Fw: Planning Consultation on: LU/141/26/DOC

Please find attached the revised drawings, updated drainage calculations and the designer's response addressing the two comments:

I'm contacting in respect of application LU/141/26/DOC to discharge Condition 10. We have received the attached consultation response from the ADC Drainage Engineers. They are requiring further information be submitted before they can recommend approval. Please could we request that you review the attached, and provide the required information to us by **27th July**.

Drawing file: LU_141_26_DOC / 519.1.VCE.0500 T4 - Overall Drainage Layout.pdf

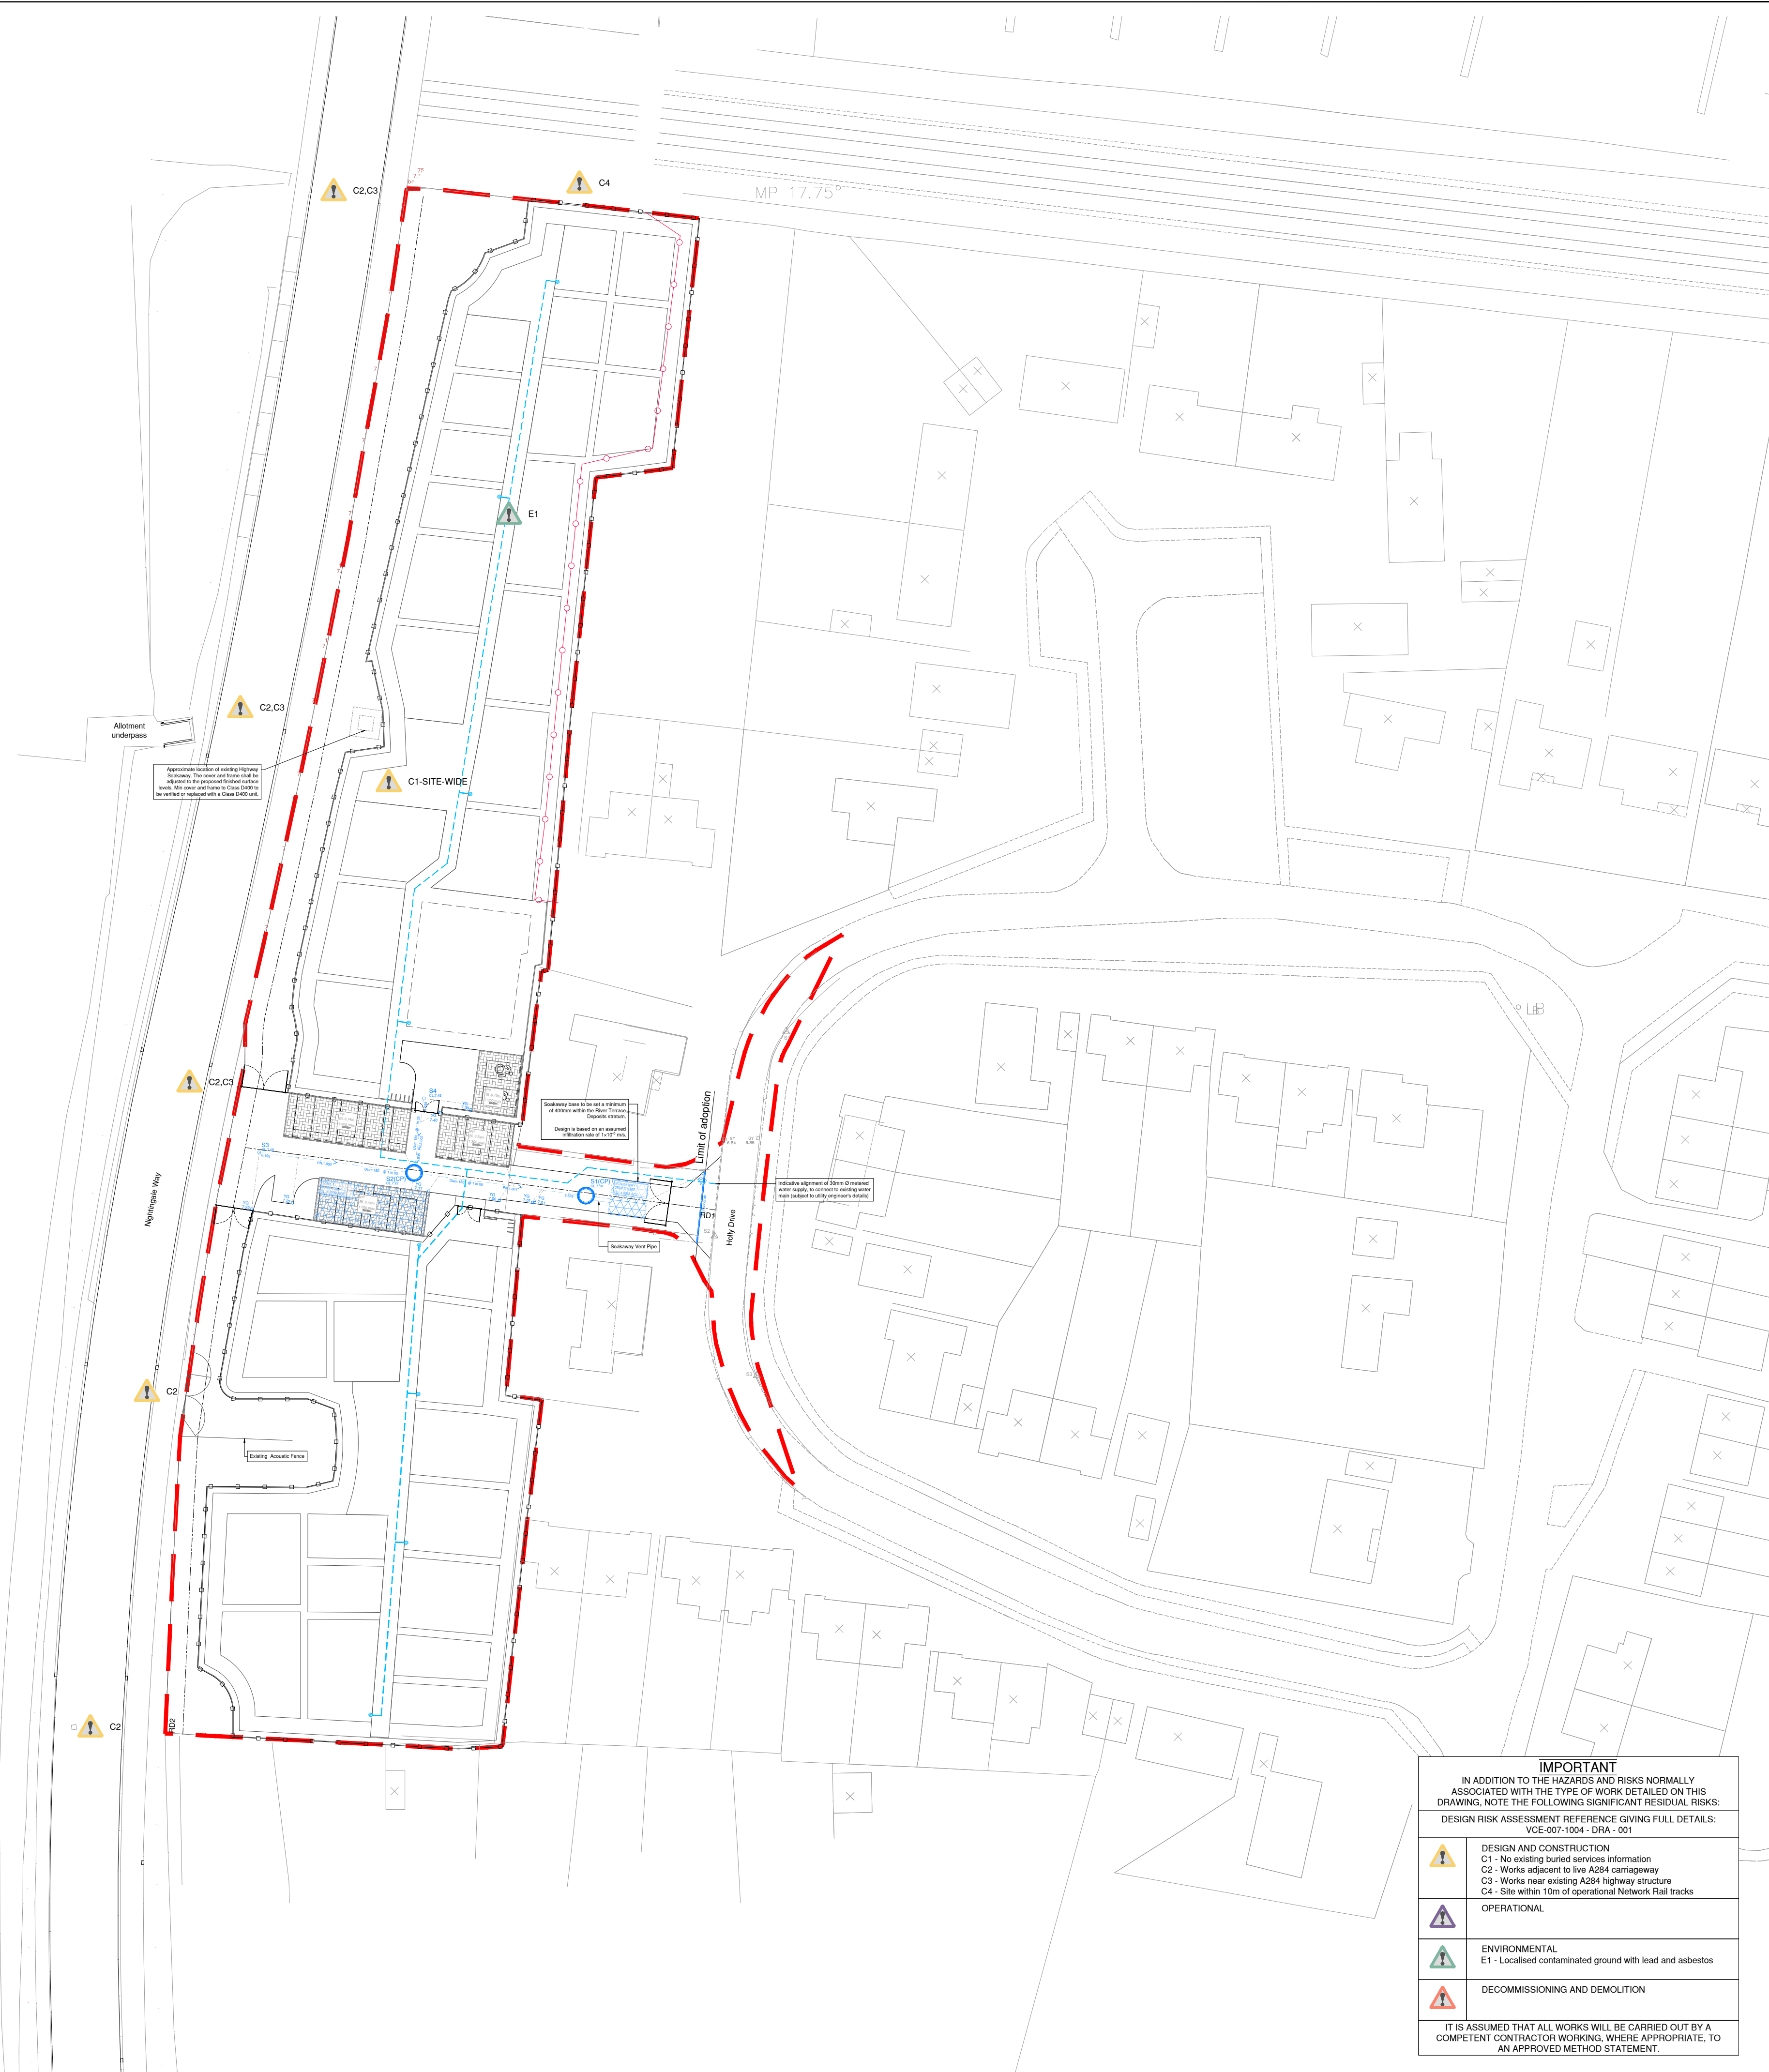
- The calculations have been re-run with the MADD factor set to 0m³/ha, as requested, however, this has not made any significant difference to the results.
- The other comment relates to the separation between the soakaway base and the highest recorded groundwater level. The previous detail referred to both a min. 1.0m separation and a 400mm penetration into the River Terrace Deposits. When the levels are worked through, the 400mm penetration gives a separation of 930mm rather than 1.0m. This was previously left as shown because the difference is only 70mm, the cover level at BH1 is interpolated, and raising the soakaway base to achieve the full 1.0m separation would mean the required half-drain time is no longer achieved. In practical terms, it is a choice between a marginal reduction in separation and a soakaway that does not meet the required hydraulic performance.

NB: The attached ZIP only contains the revised drawings and calculations. The only design change is a minor adjustment to the soakaway base level, as explained above.
